From: Richard Castro-Parker
Sent: 10 December 2018 11:31
To: Planning.Responses
Cc: Daniel Vick
Subject: FW: AW/85/18/HH

Please could these further (updated) conservation Officer Comments be uploaded to AW/85/18/HH -- 54 Kingsway.

AW/85/18/HH

These comments are based on revised plans, submitted in August.

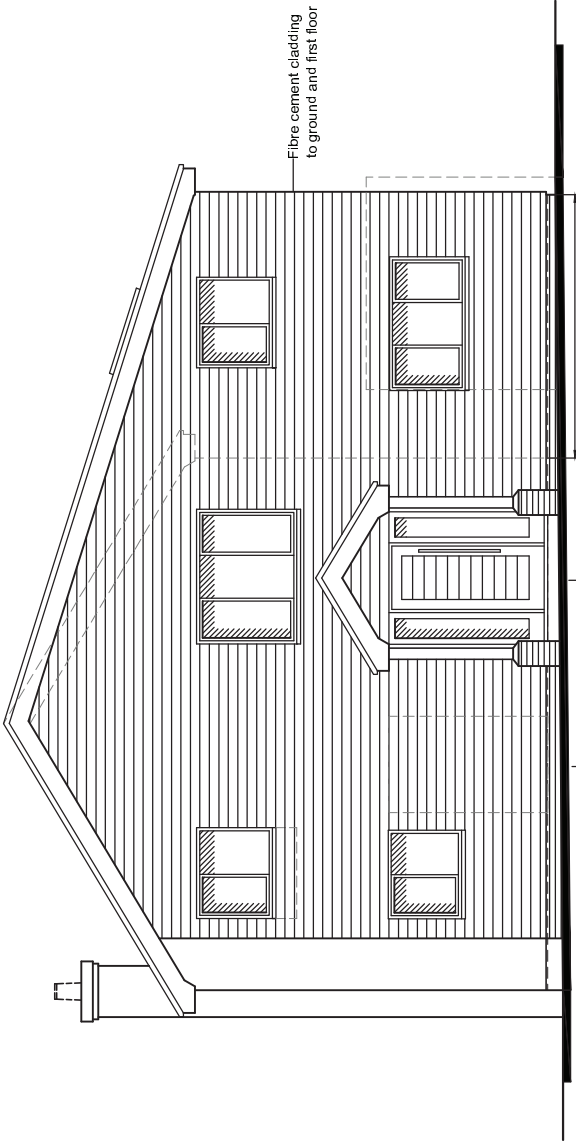
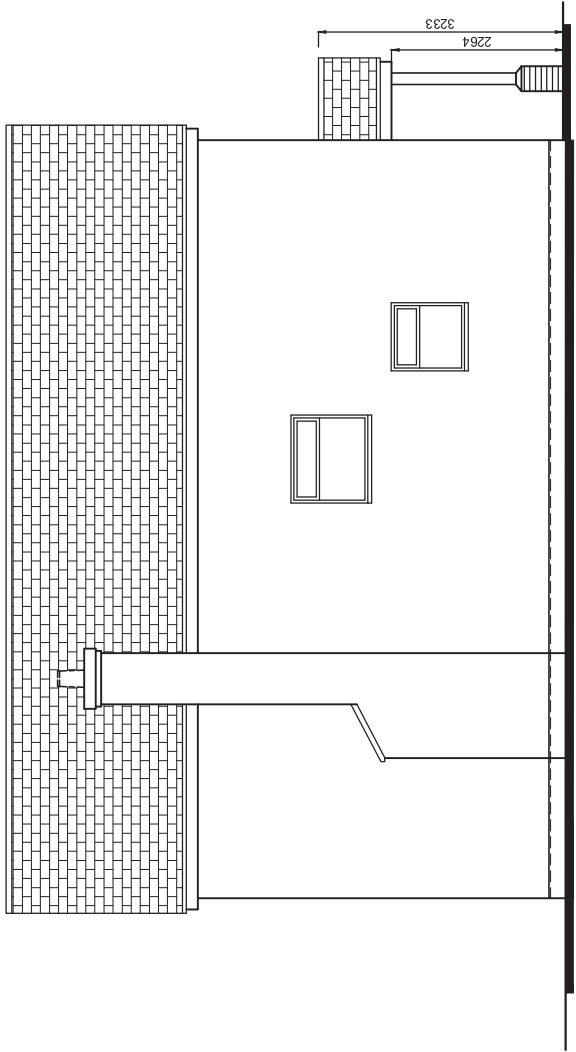
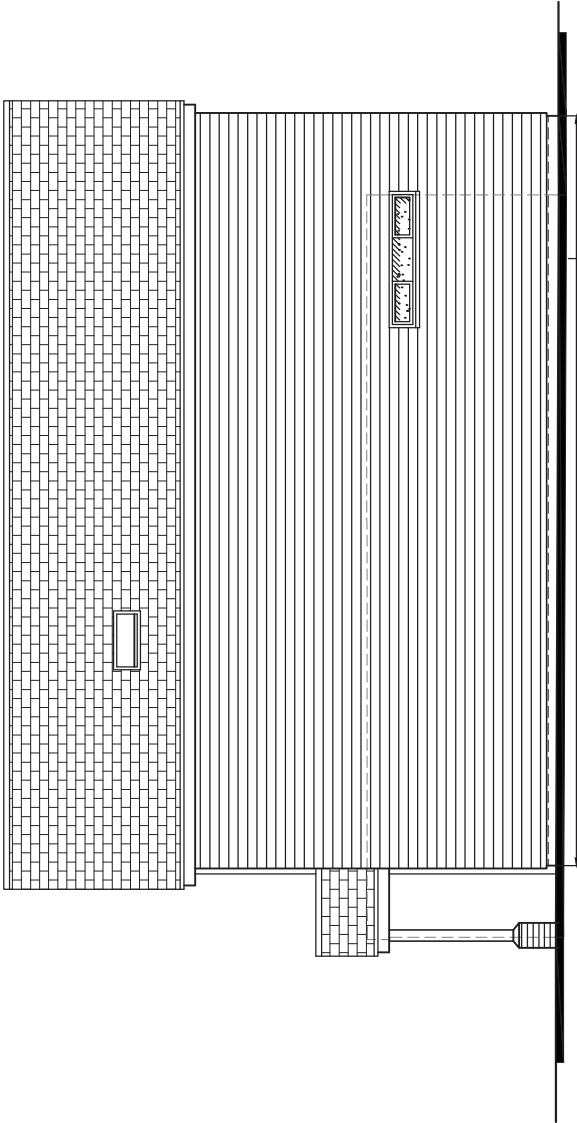
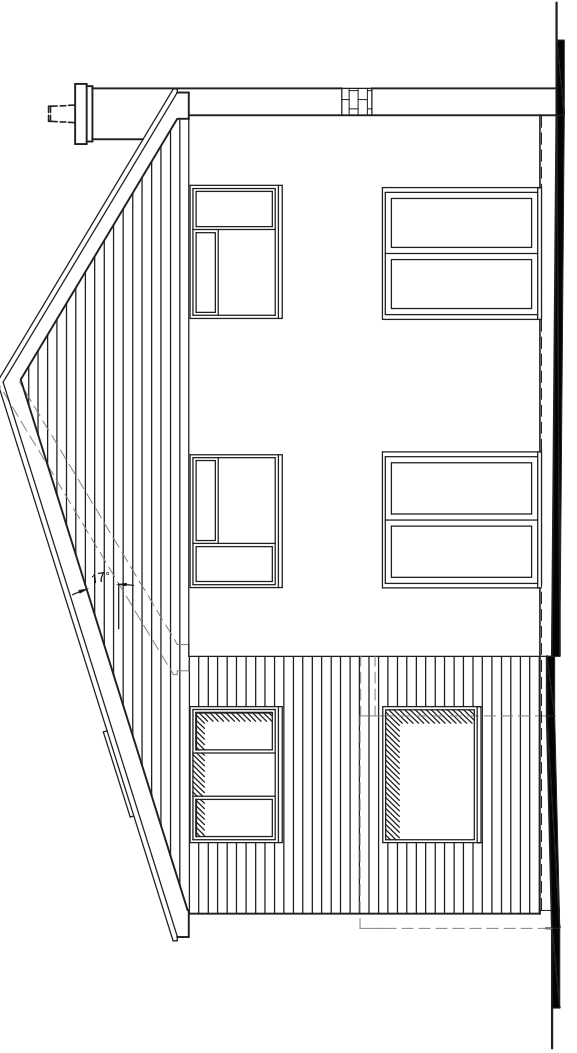
The revised two storey side extension is more in keeping with the host building in terms of its location, size and the resulting roof form.

The revised proposal is therefore considered to be more in keeping with the properties within the local area, i.e. through the use of render on the front elevation. However, it is not clear from the plans what the cladding will look like, or what colour it will be. There is also limited information as to the colour of the windows, front door, and roofing materials. Such detail will affect the impact of the proposal upon the local area, and should be provided.
